Name of Project: Flatwoods Middle School

Date: November 11, 2025

Re: Wet Pipe Sprinkler Systems  
Comments Addressed Ref. Optima # 24-0049R  
HCS Flatwoods Middle School  
3544 US 401 South  
Lillington, NC

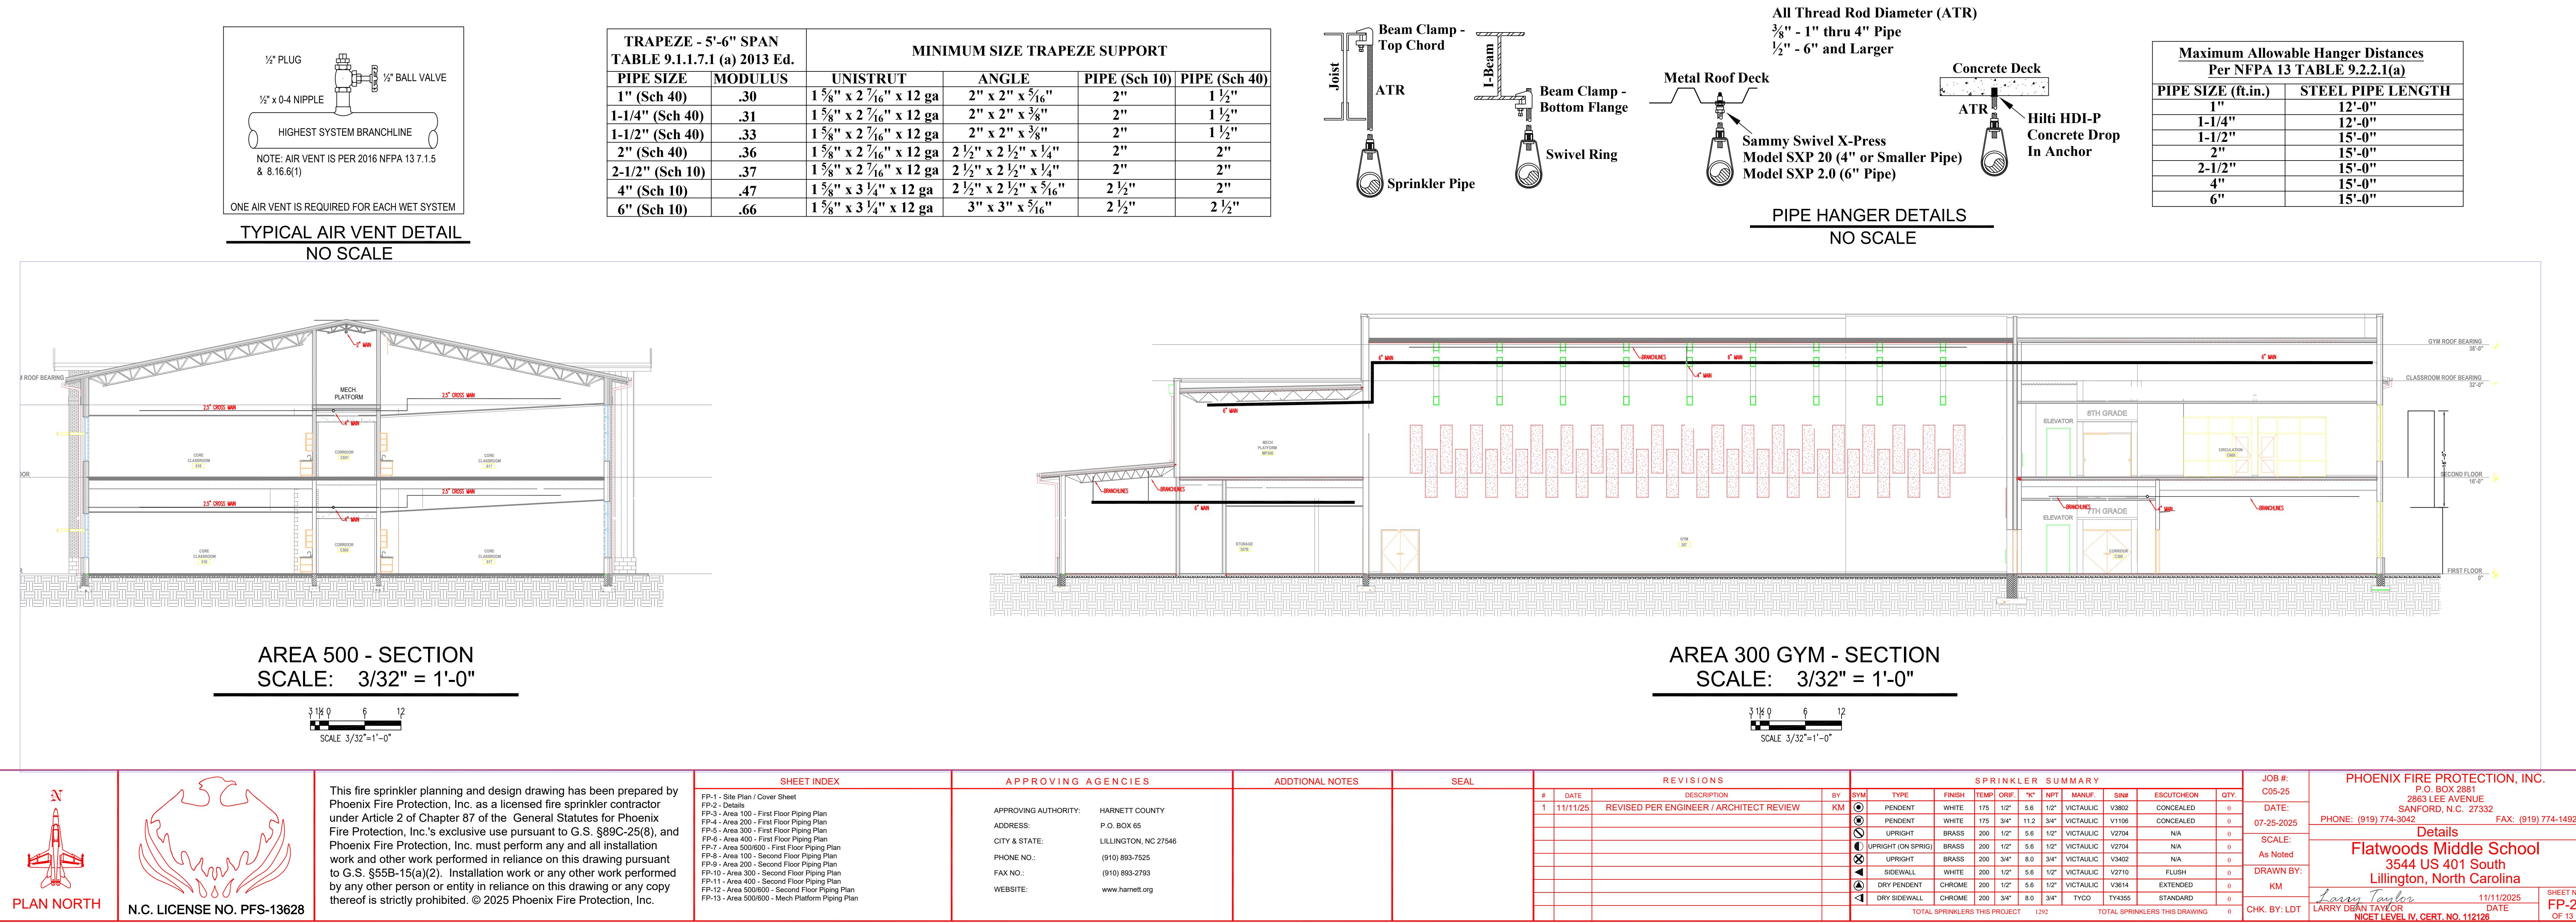
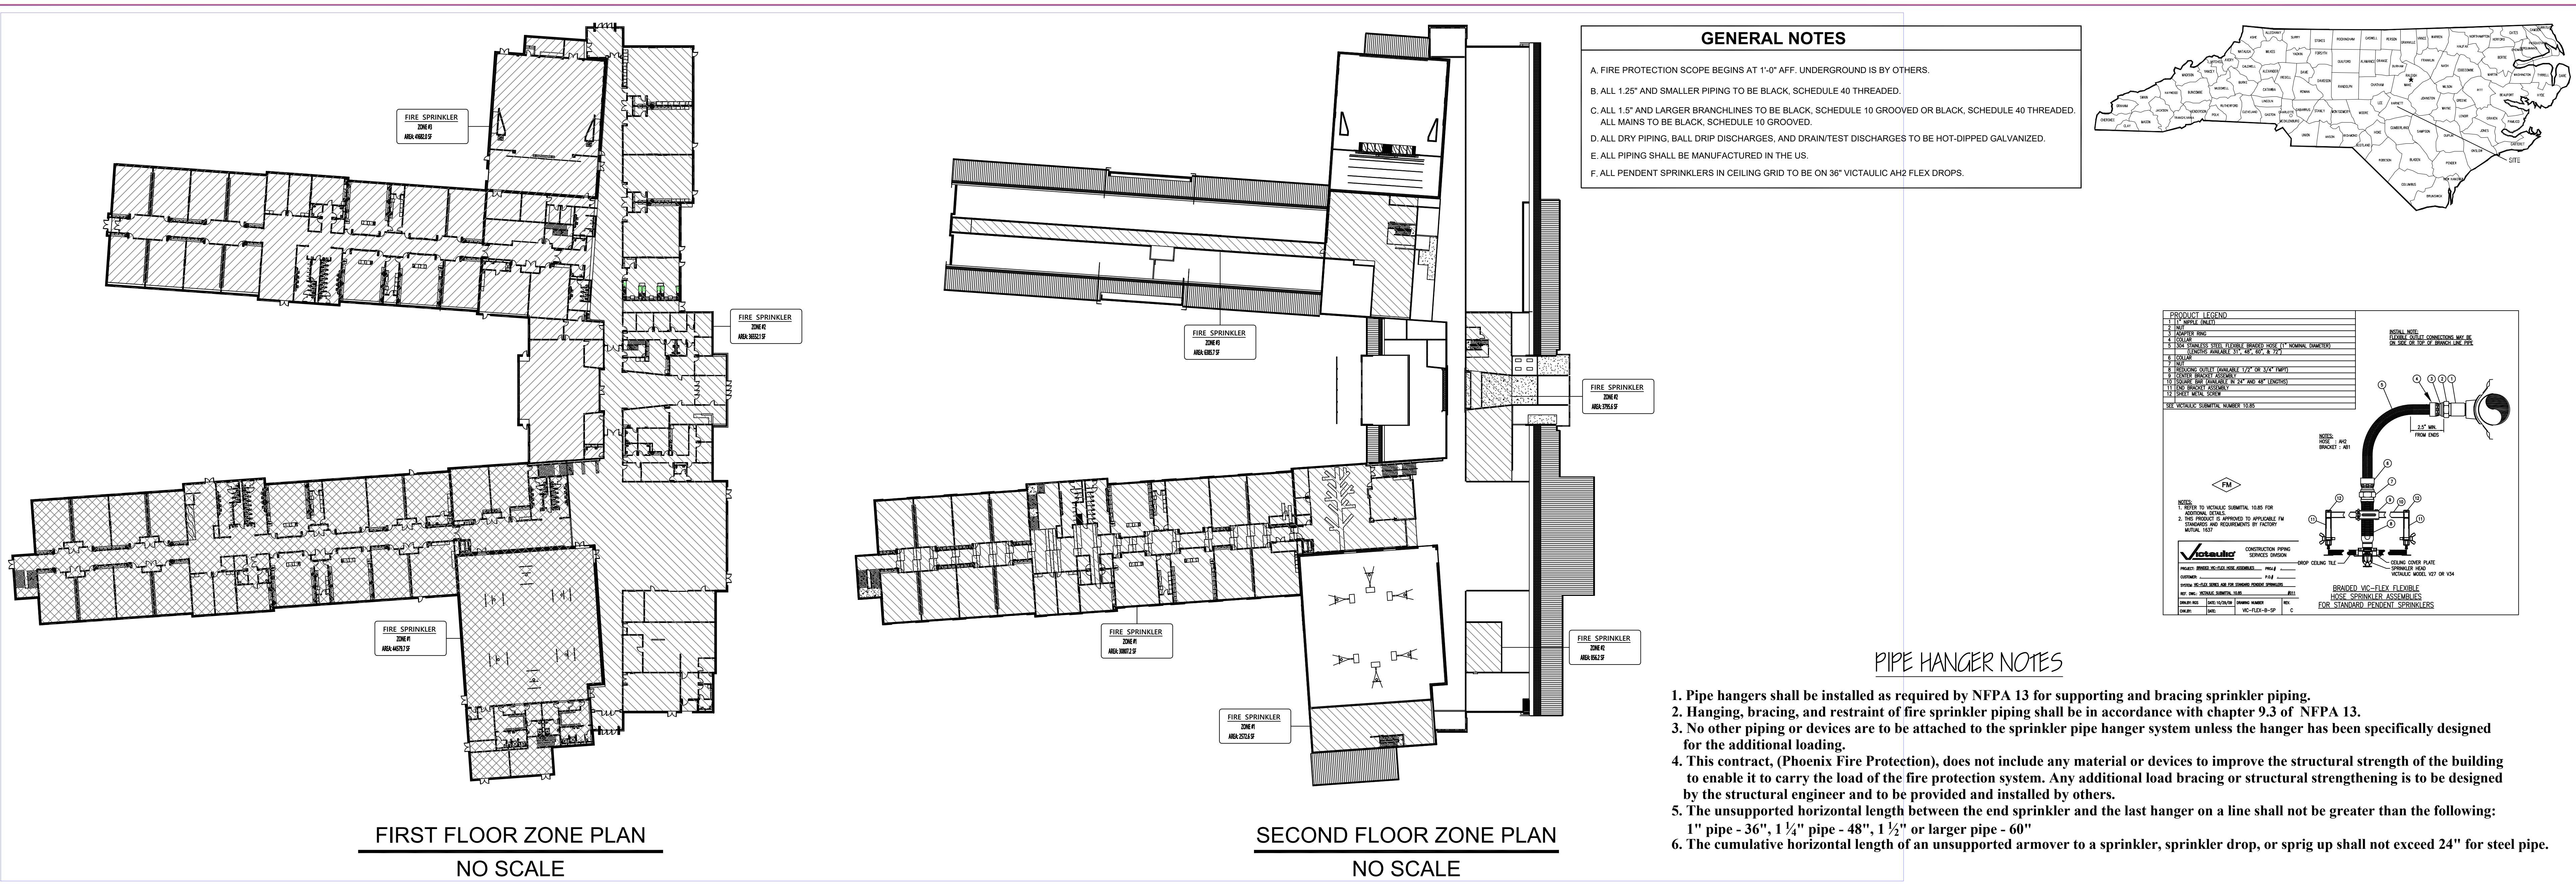
Sheet FP-3:

- Branch line has been relocated to run south and then pass through bulkhead
- The sprinkler shown outside of Lobby has been removed, it is not required.
- A 4-inch fire main has been added running down the East wall with the branch lines running between beams.
